Amended Plans Form

Application Number: 11/00282/DISC

Address (including postcode): Portway
Heyford Park

Summary of amendments/additions (Note: this is the extract text that will go out on the consult letters): Please find attached an updated drawing (drawing ref: D.0342_51-1F) as requested with the edging material removed entirely and excavating a further 150mm and adding another 150mm of Coxwell Gravel.

Heyford Park - Proposed Bridleways Routes

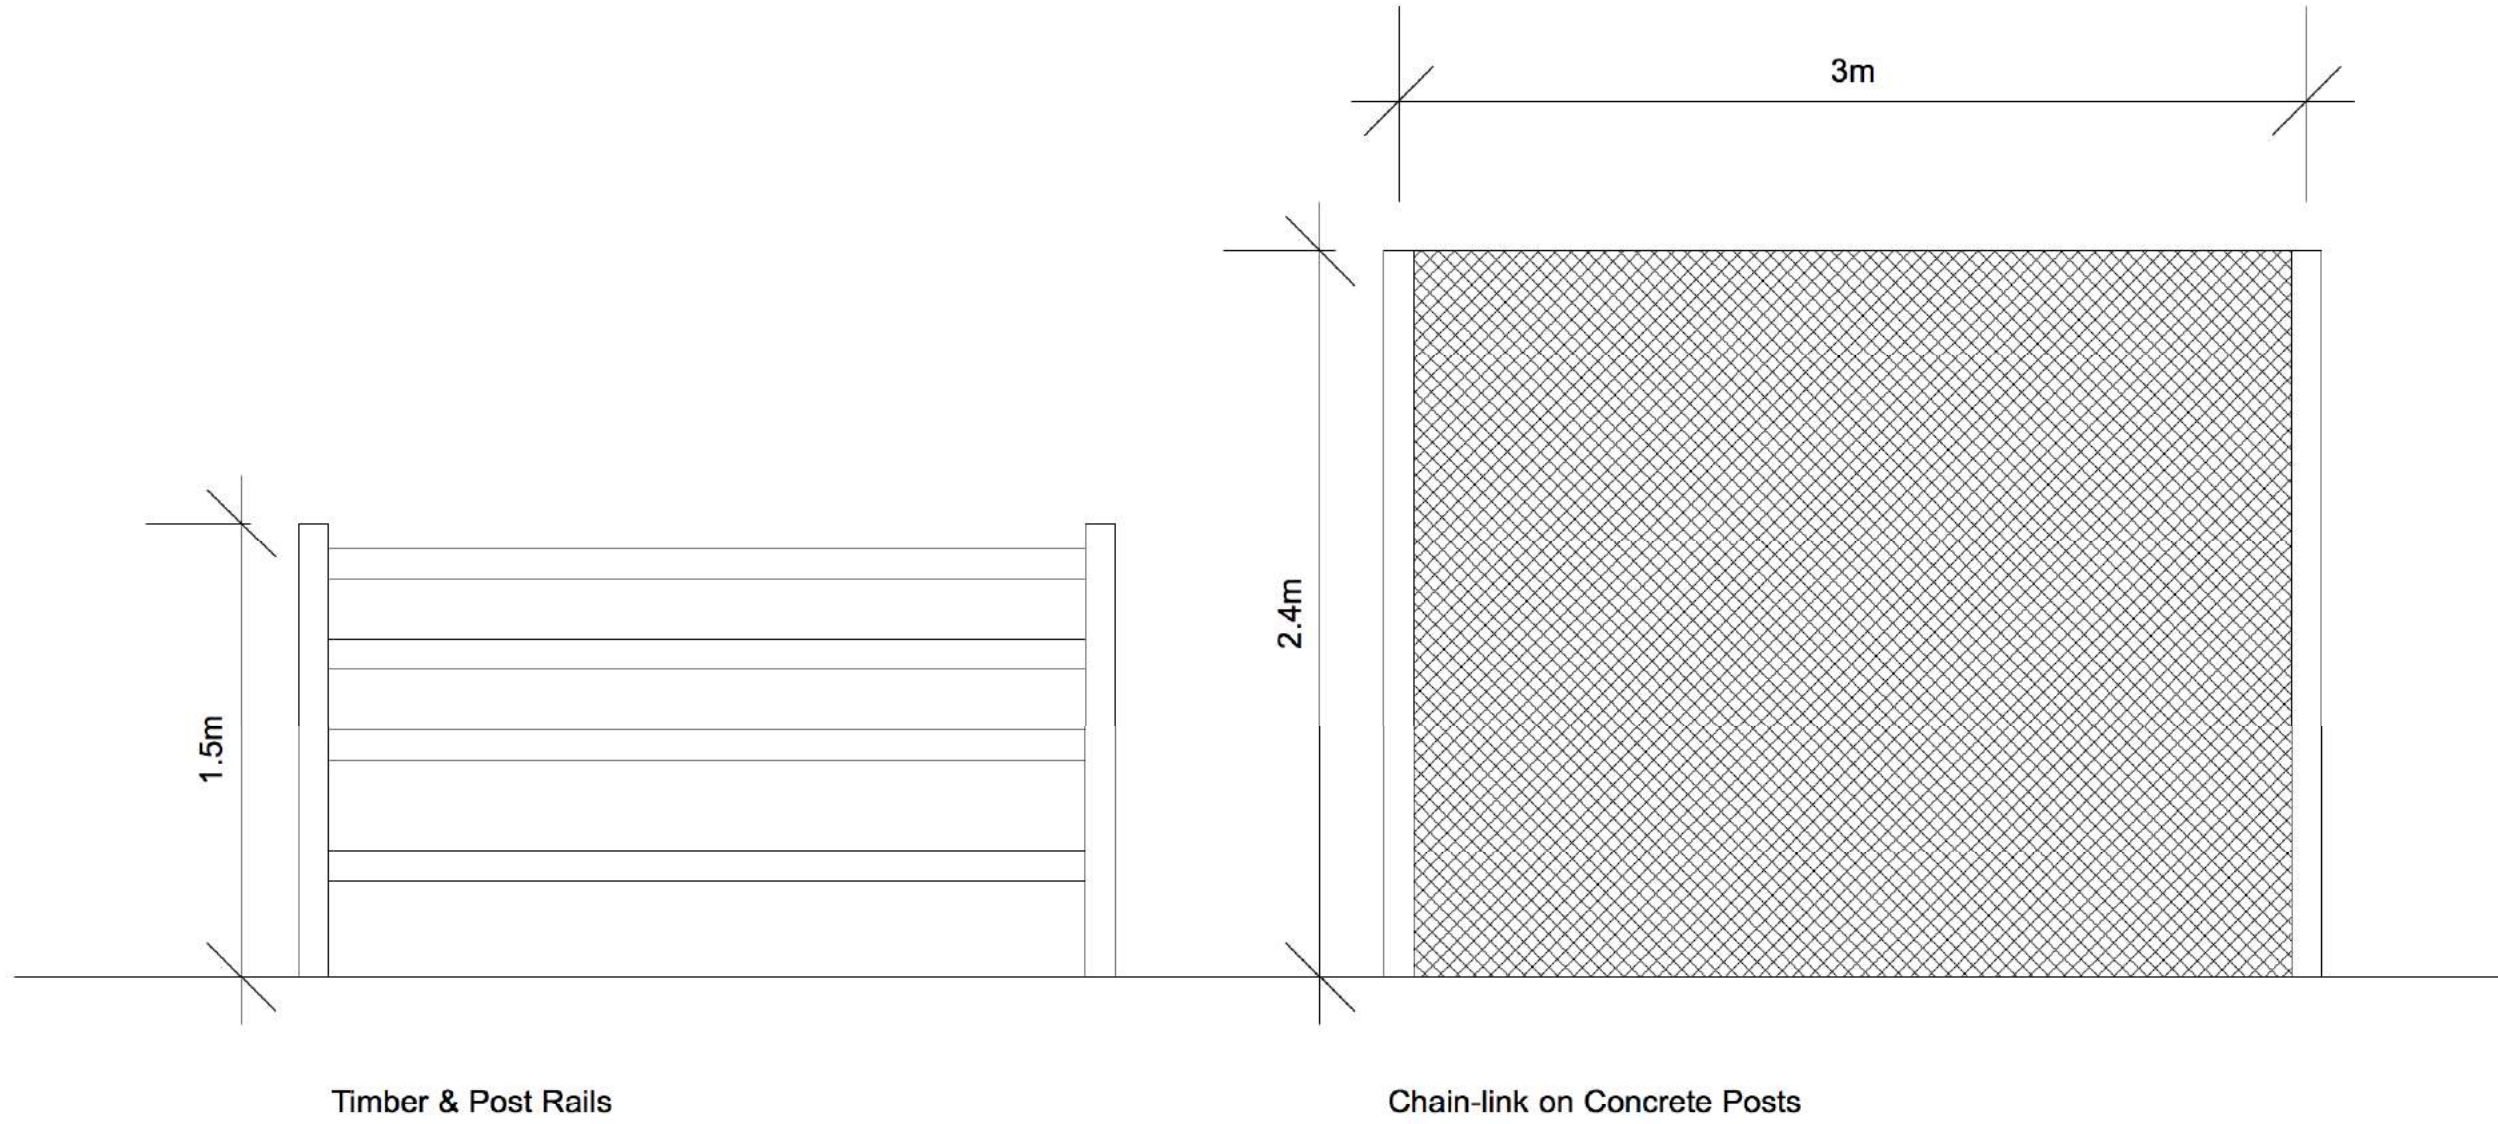
The submitted drawing supersedes drawing ref: D.0342_51-1C previously submitted.
